Re: Mr. and Mrs. Stummer

Pendle View Barn, Moorgate Lane, Dinckley, BB6 8AN

Application: 3/2022/1038.

Proposed Site Plan - 1:200

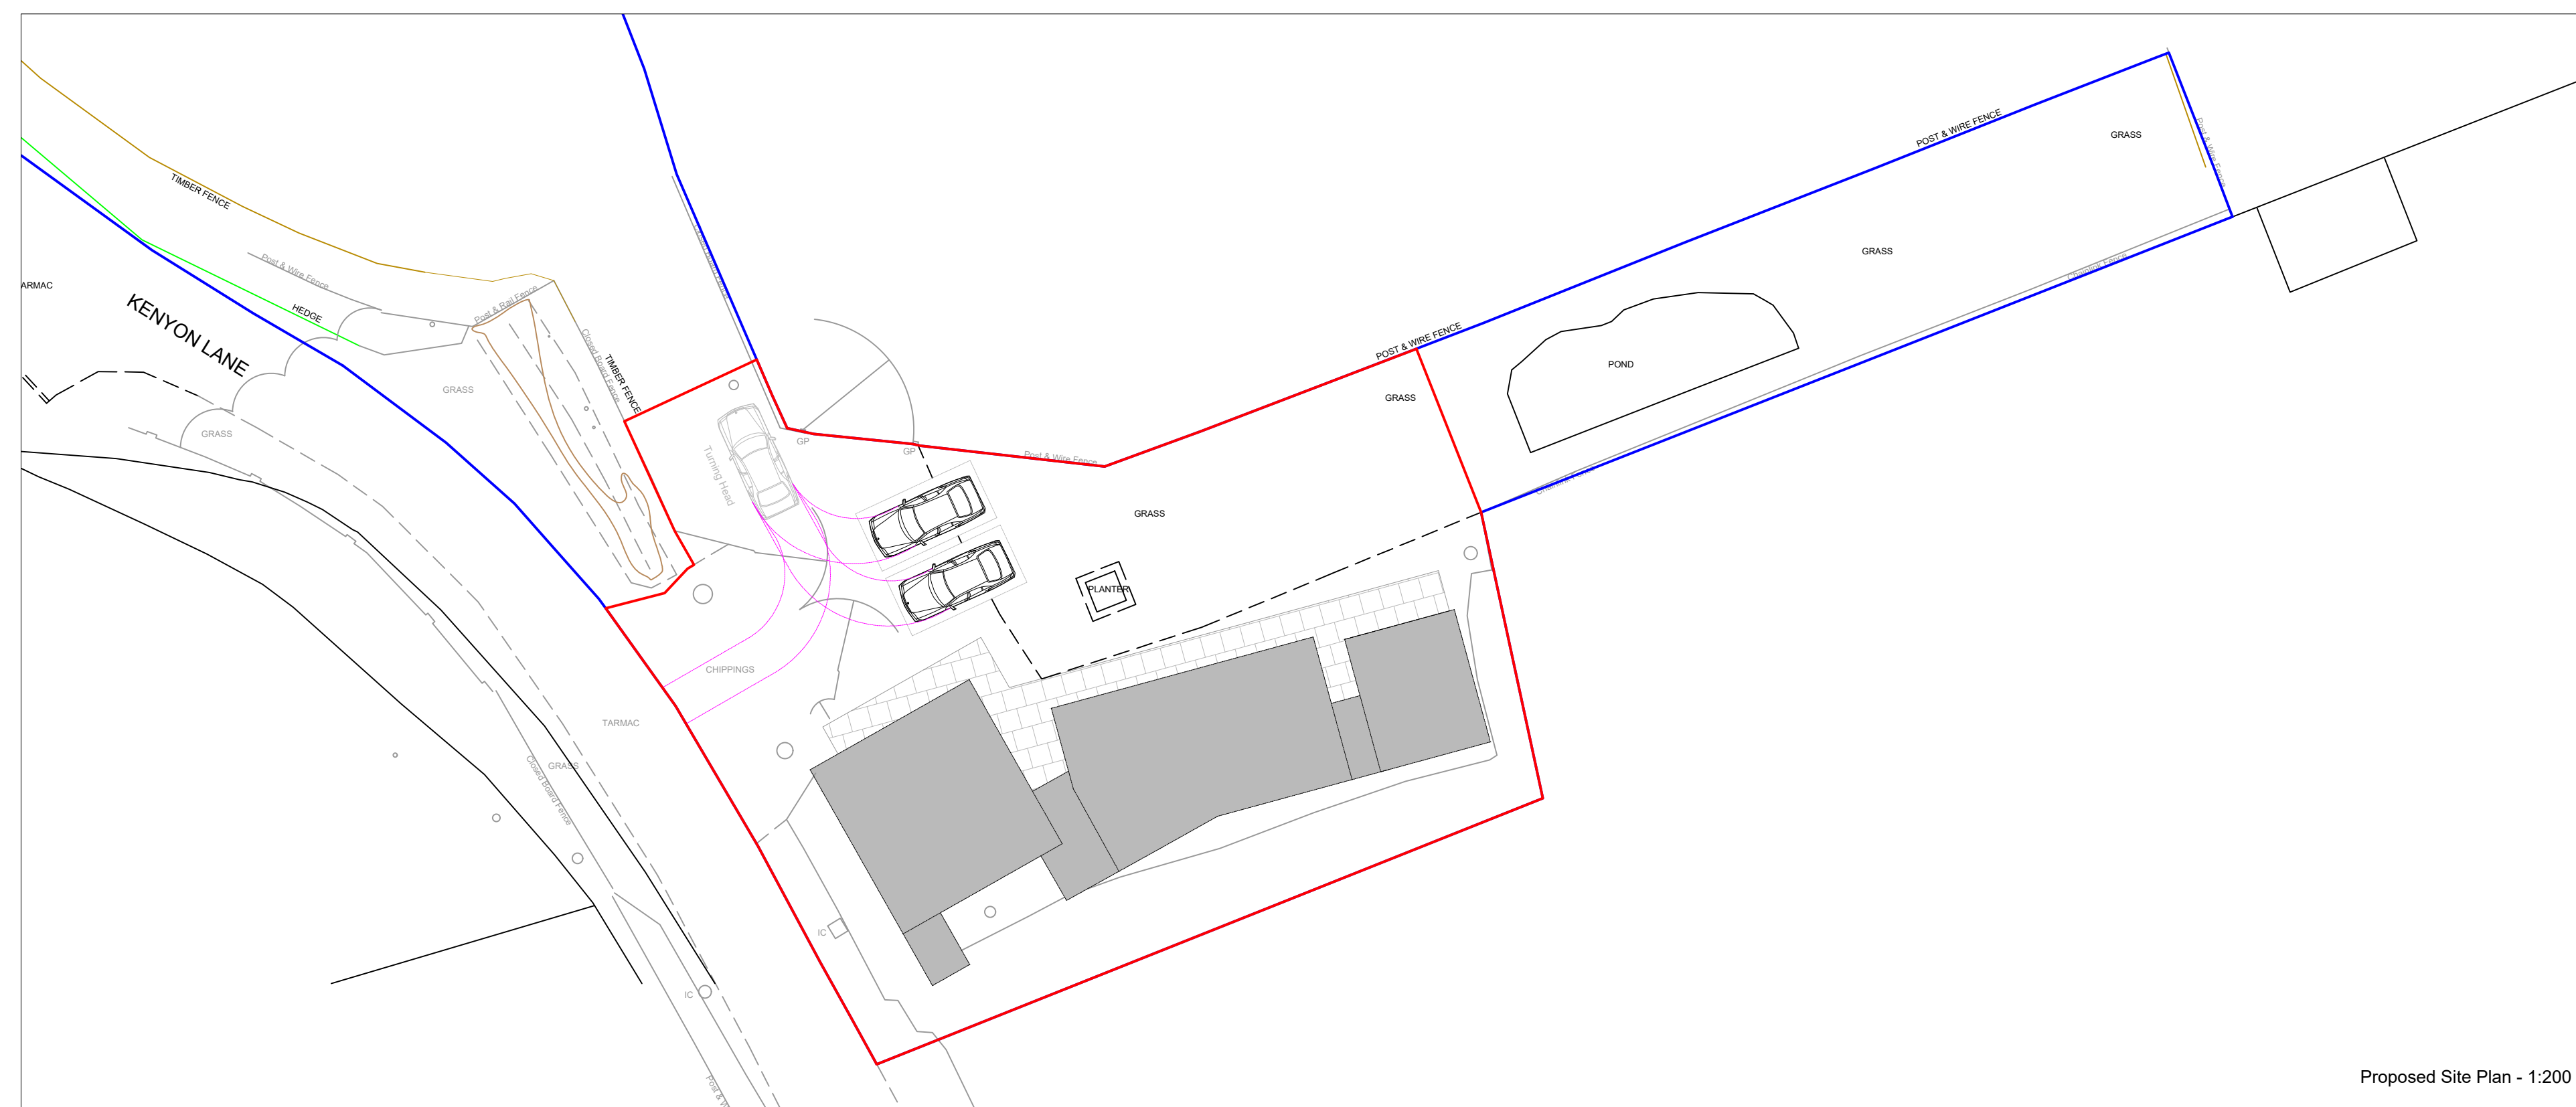
We note the applicant has provided a plan which purports to demonstrate that the Highway Authority requirements for visibility splays to serve the proposed development can be satisfied. We wish to point out that the applicant does not own nor control the area within the suggested splays and is therefore unable to guarantee that it will be free from obstruction in the future and as a result cannot be considered to be an acceptable solution.

We assume the Council will require the applicant to make alternative provision or refuse the application.
